SF19012-R3-Plat-redlines.pdf Markup Summary

SF19012-R3-FDR-redlines Summary_Markup Summary

SF19012-R3-CD-redlines.pdf Markup Summary

TYPICAL SECTIONS

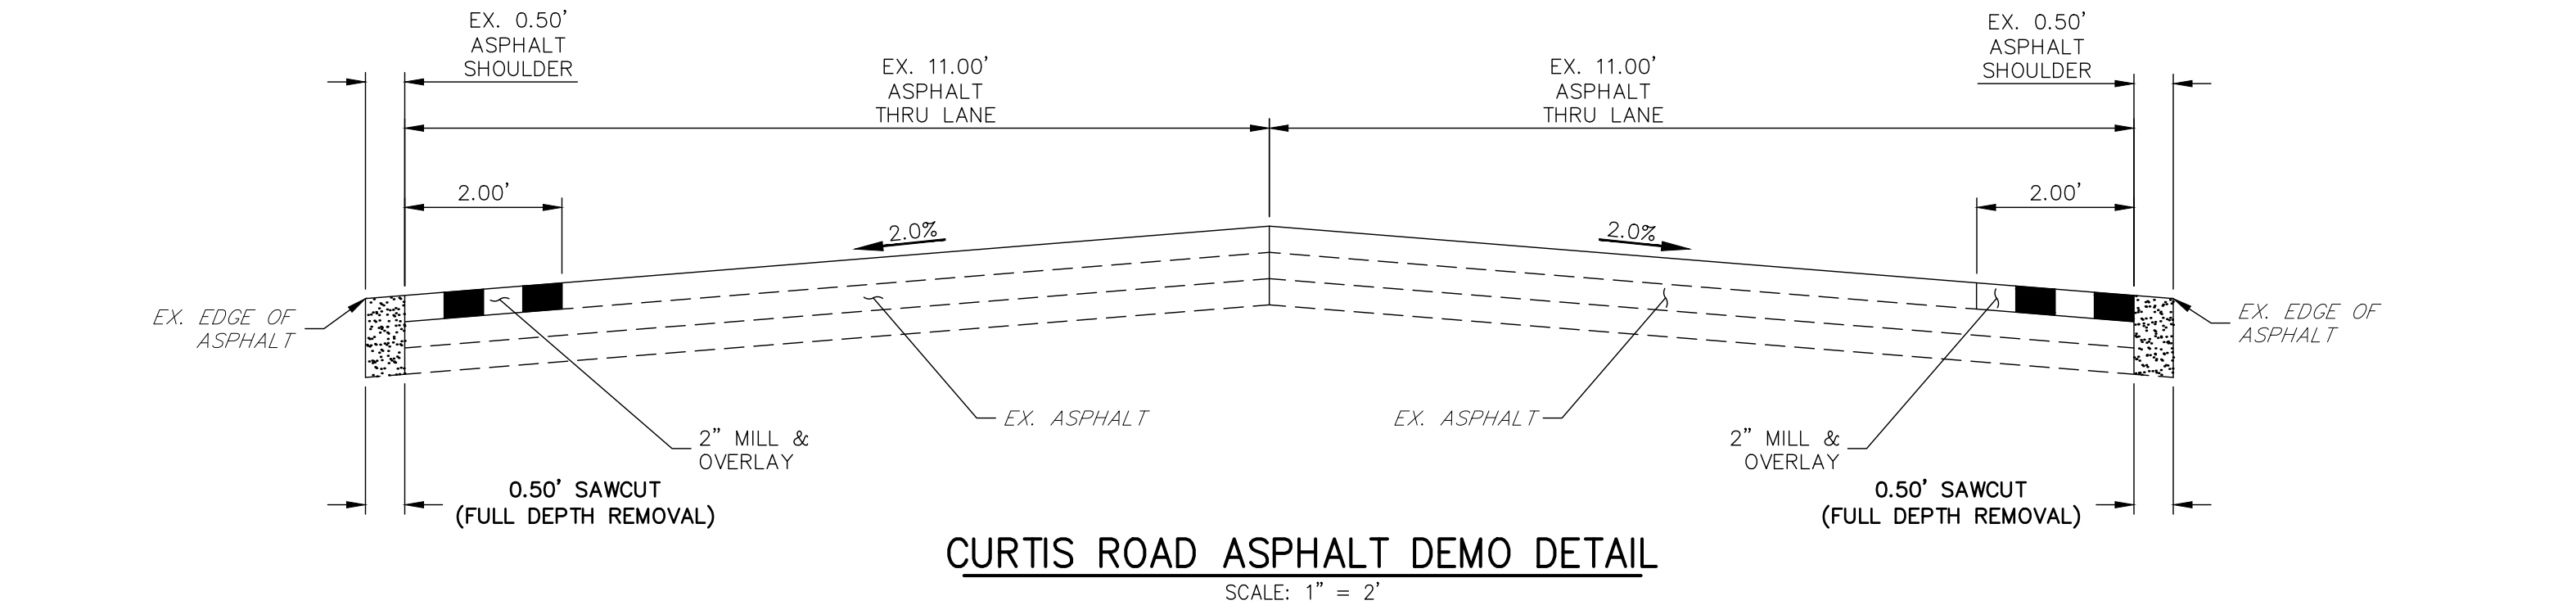
remove "full depth asphalt"
and replace it with
"Composite asphalt section"
on these details. These
improvements are subject to
a pavement section design.
